Re: LU/323/I9/HH

I wish to make objections to the above application as follows:

Ref: L03401

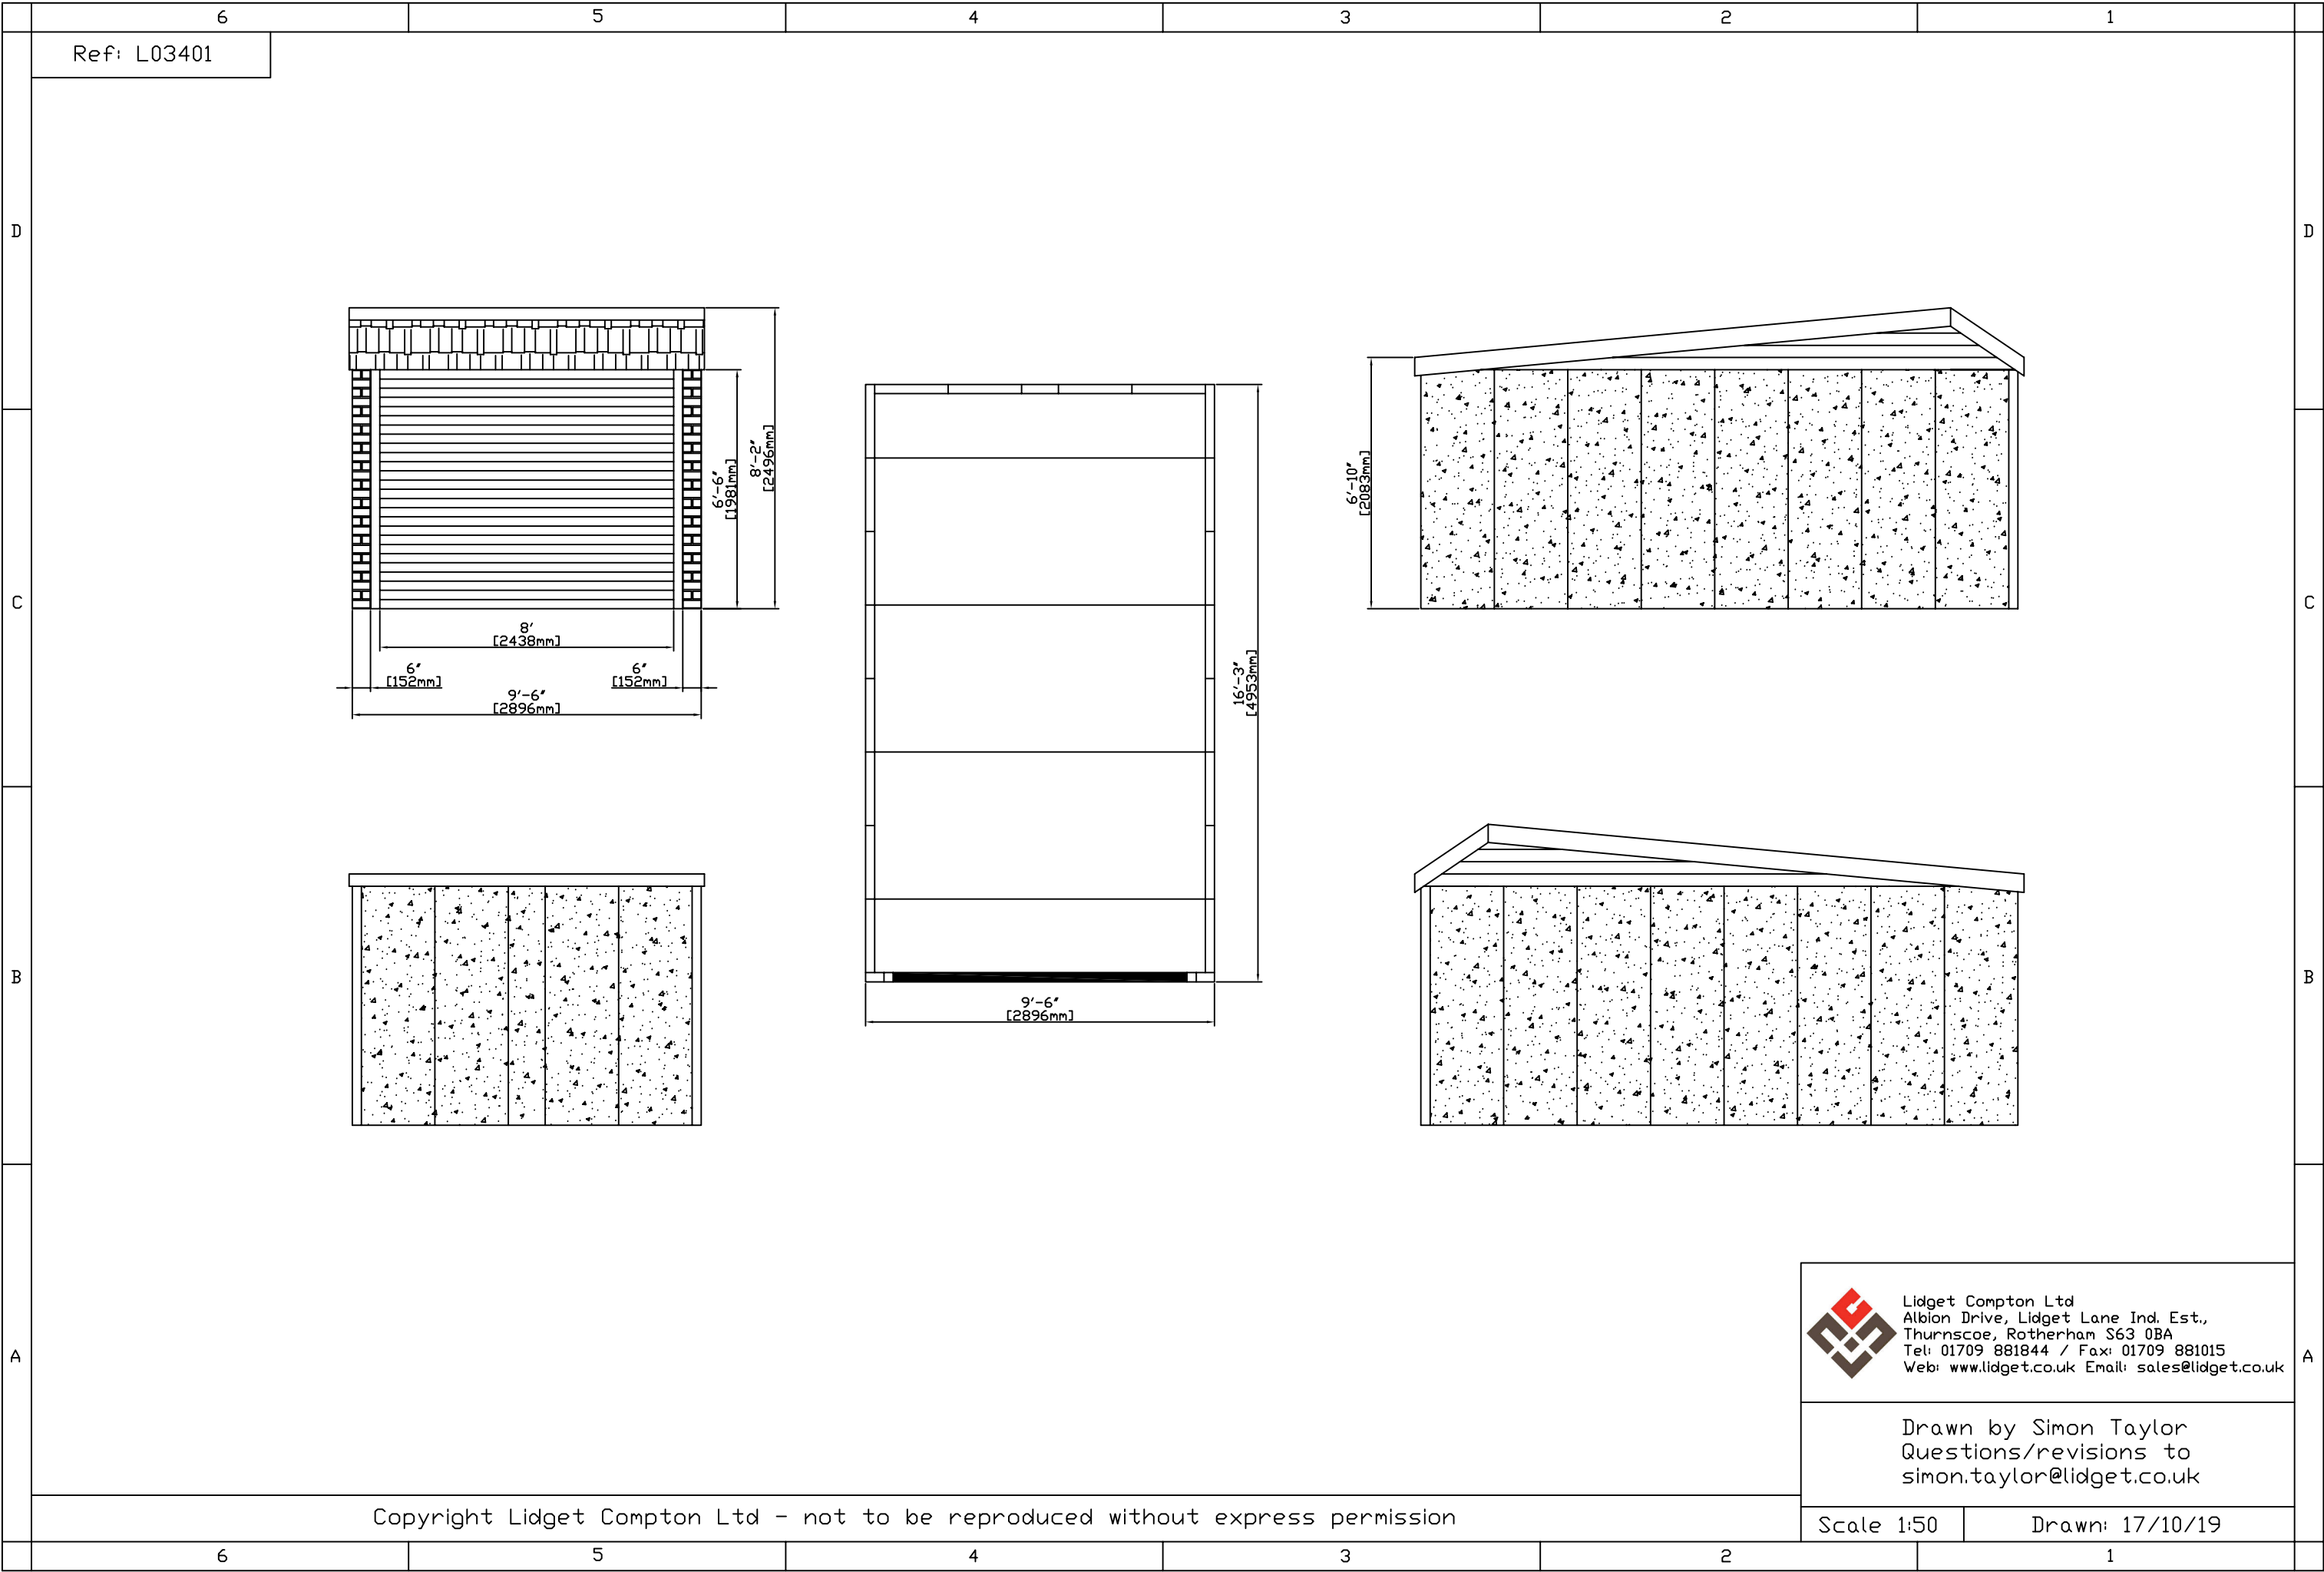
4. Incorrect answers have therefore been given in respect of "parking and vegetation".
5. No mention is made of rain water drainage from the roof, which appears to slope onto my boundary. This would cause a permanent nuisance.

6. The garage would be out of character with the other garages being concrete not brick.
7. No other parking spaces have been built upon in the estate. There is no room to do so upon 2.4 metre widths, which is probably why this was not built in the first place.

proposed block plan

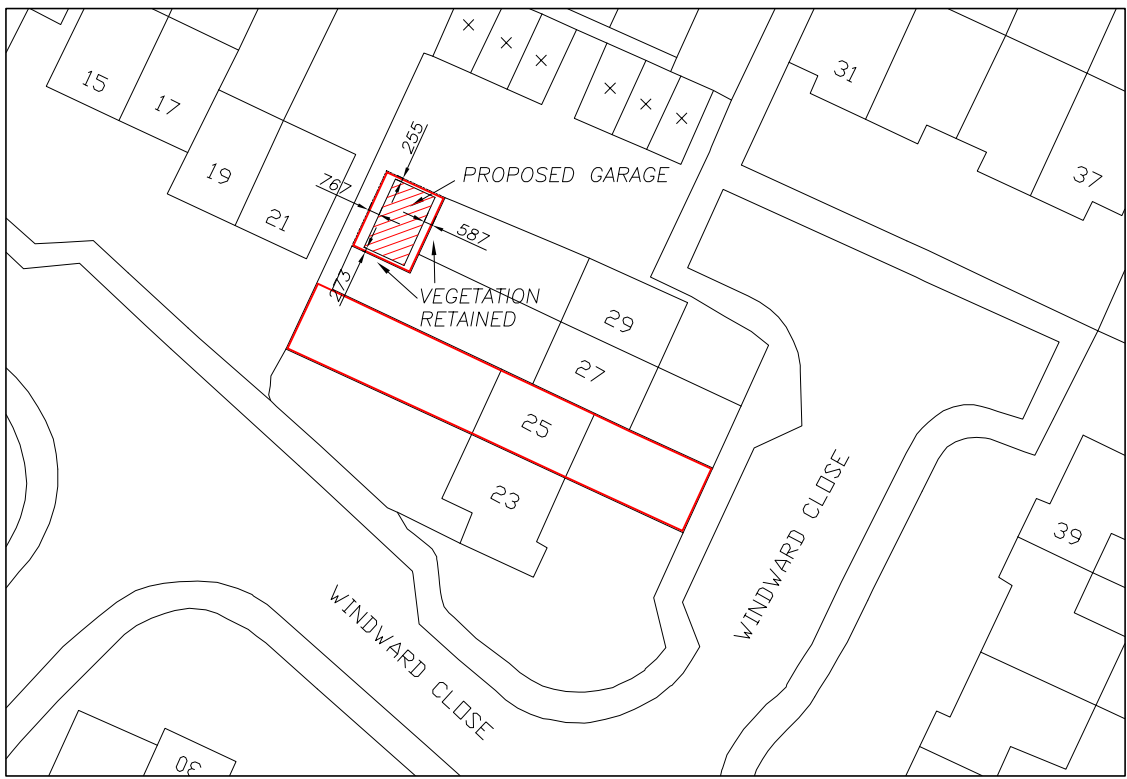
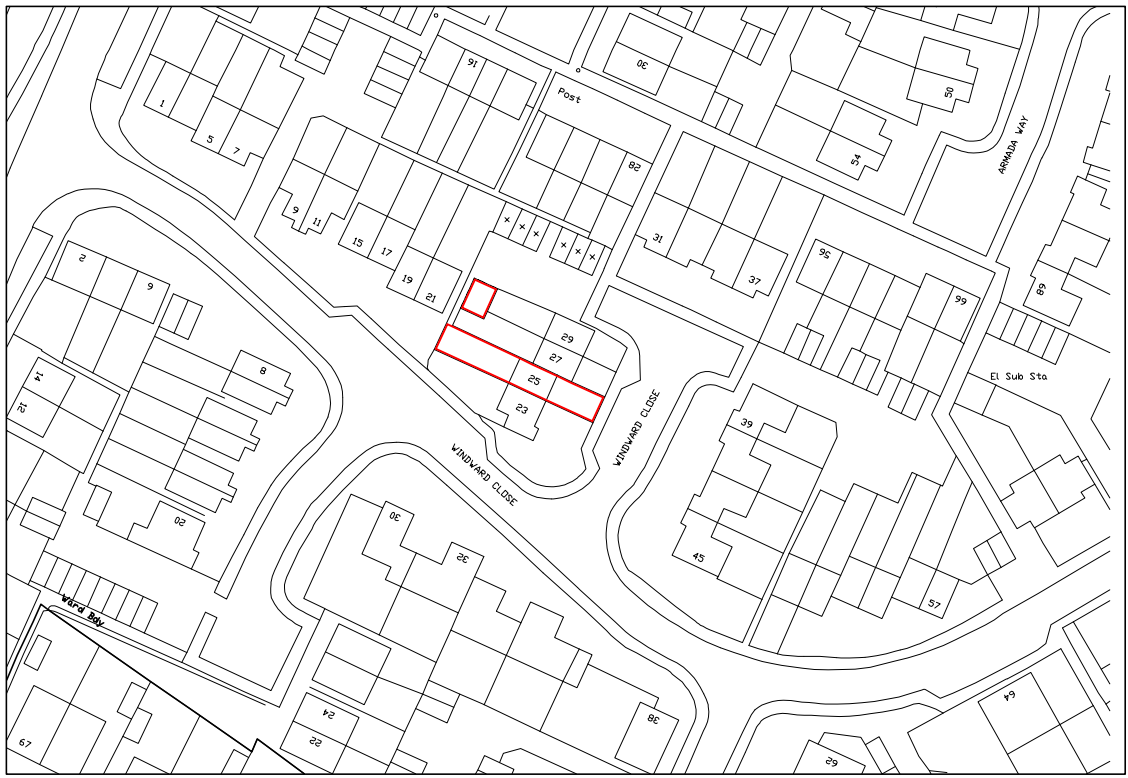
1. Certificate A has been incorrectly completed. The applicant does not own the area marked in red on the block plan. He owns approx. $\frac{1}{2}$ of the site, 2.4 metres wide.

2. Please refer to Land Registry plan WSX 33737 dated 26.4.79. Building across 3 metres would intrude onto existing turning space for other garage owners and residents, who have a right to pass and repass.

3. My Deeds give right to access onto neighbouring land, including this parking space, for maintenance purposes. I have exercised this right for many years to renew and treat fencing. If the garage were built I would need to remove trees to gain interior access only. Removal of trees would make the garage intrusive.
